Submission for the Hunter Transmission Project – SSI-70610456

Please accept this submission regarding the EIS for the Hunter Transmission Project from the Centre for Conservation Science at the University of Newcastle. We have serious concerns about the proposed creation of the transmission line and placement of the Olney State Forest Switching Station due to the significant impact they will have on the Watagans population of endangered Littlejohn's tree frog. Although we support the transition to renewables, we request that an alternative location be used for the switching station, and that further consideration be given to underground construction options.

Figure 5: Olney Switching Station Location.

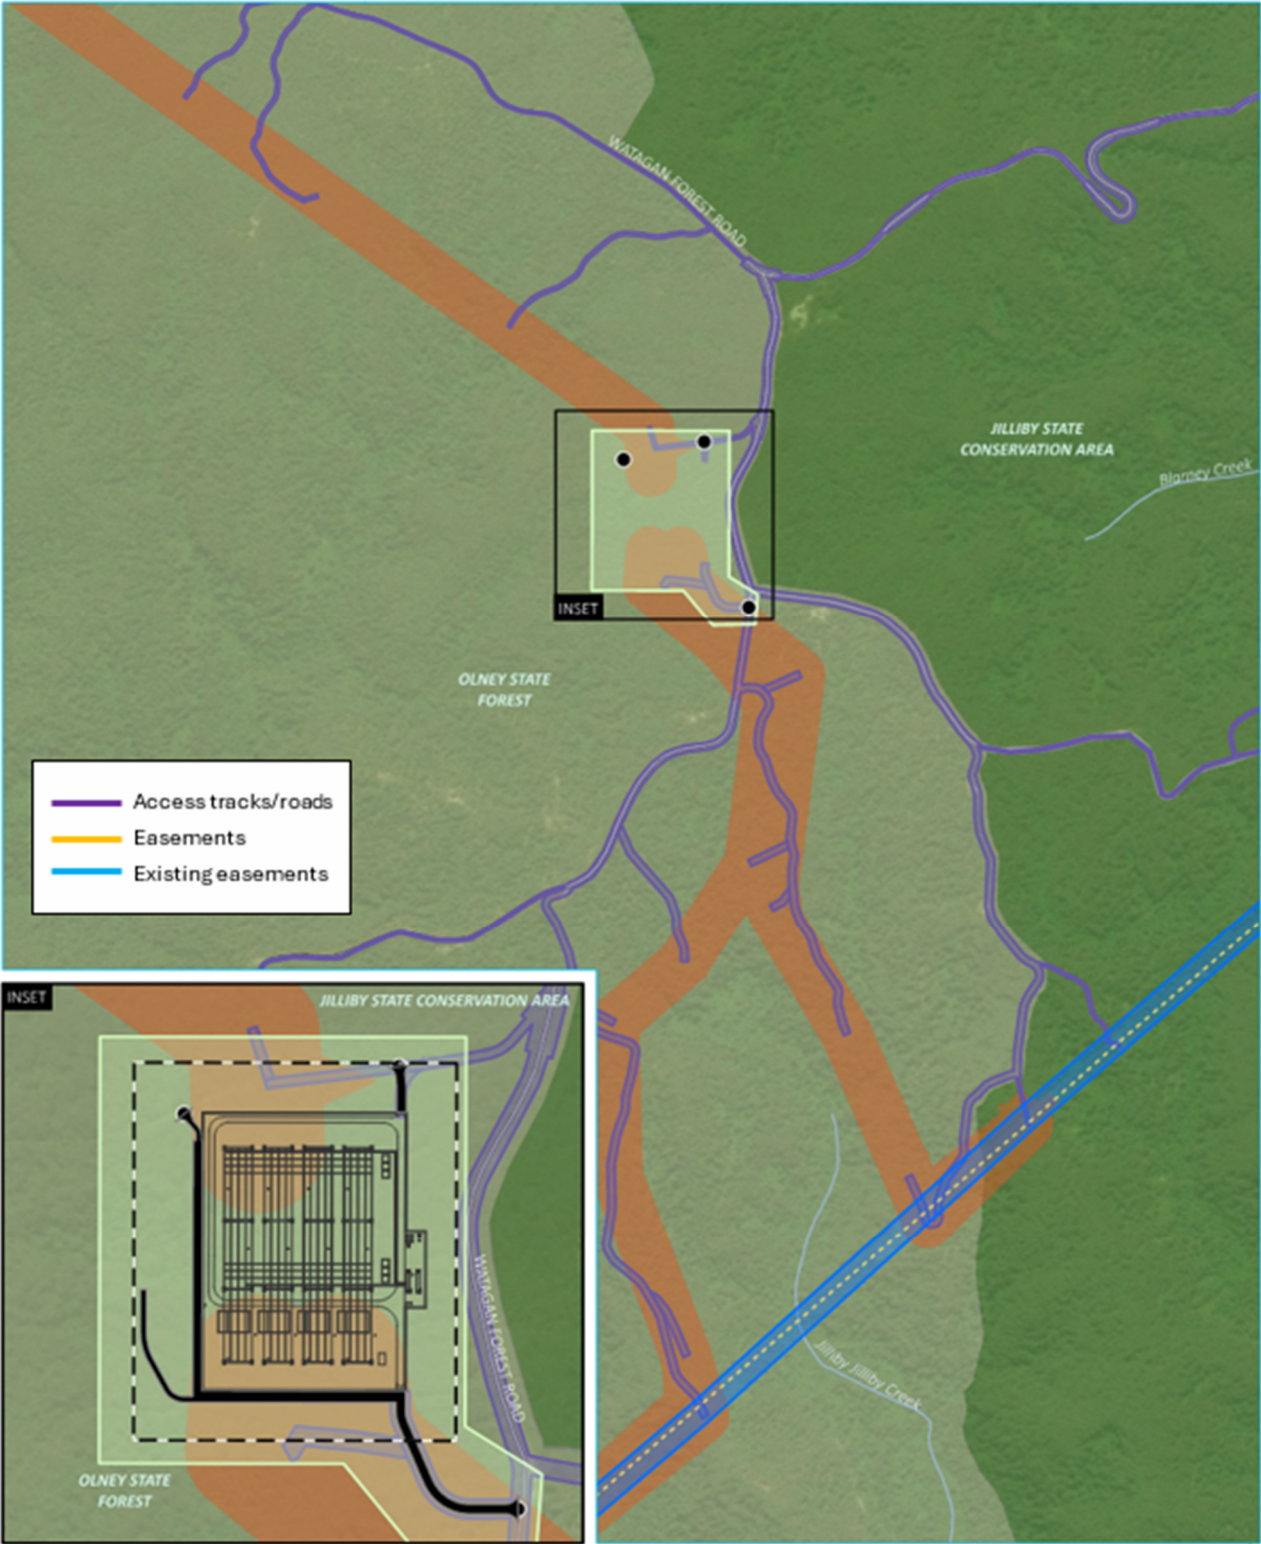
The Hunter REZ Transmission Project threatens this fragile population. It proposes transmission towers alongside sites of the original population and the newly created ponds, places the Olney State Forest Switching Station directly over the southern end of the population, and cuts through habitat at the northern end. These actions will destroy critical breeding sites and significantly impact the entire population.

While the EIS claims the preferred route avoids at least four artificial breeding ponds, there are known, occupied ponds within tens of metres of the proposed 60 m-wide corridor. The Olney State Forest Switching Station would sit atop several key breeding sites that have been monitored for over 20 years. This species is only known from this <5 km stretch of ridgeway (from just south of the proposed Olney site to the Pines picnic area), and large-scale construction and land clearing here poses a serious threat to its survival. Map 3.11 of the EIS omits Littlejohn's tree frog sightings, which would show that this species is only found in proximity to the proposed Olney State Forest Switching Station site. Even if some ponds remain intact, the degradation of surrounding terrestrial habitat — crucial for dispersal and survival — could be devastating as forest fragmentation in other populations has likely isolated them (Stock et al., 2022).

The EIS states that the Olney State Forest Switching Station site has “social benefits ... combined with reasonable technical, environmental and cost benefits,” but we do not believe that the serious impact this site will have on Littlejohn's tree frog and co-occurring amphibians has been adequately considered. The EIS also states that “This [Olney State Forest] option does not require the 500 kV transmission line to be constructed through the communities of Martinsville and Cooranbong”. However, the options of Martinsville East and Eraring West run alongside the current transmission line, so a switching station in these locations would not require a new transmission line to be constructed in these communities, making the above quoted statement highly misleading. In fact, all seven alternate proposed locations for the switching station run alongside the existing transmission line. Furthermore, the EIS says that Olney State Forest site has “issues associated with fire and access”, which we believe to be a serious issue that warrants appropriate consideration. The proposed Olney switching station site is the most remote site option and access is difficult due to the unsealed, narrow, windy nature of the existing roads. Wildfire is currently listed as a known threat to the Littlejohn's tree frog (NSW Government 2022, Berenek et al., 2023), but it would also threaten other endangered species, forestry land, and people who use this area for recreation.

- a. An alternative site is used for the proposed Olney State Forest Switching Station**
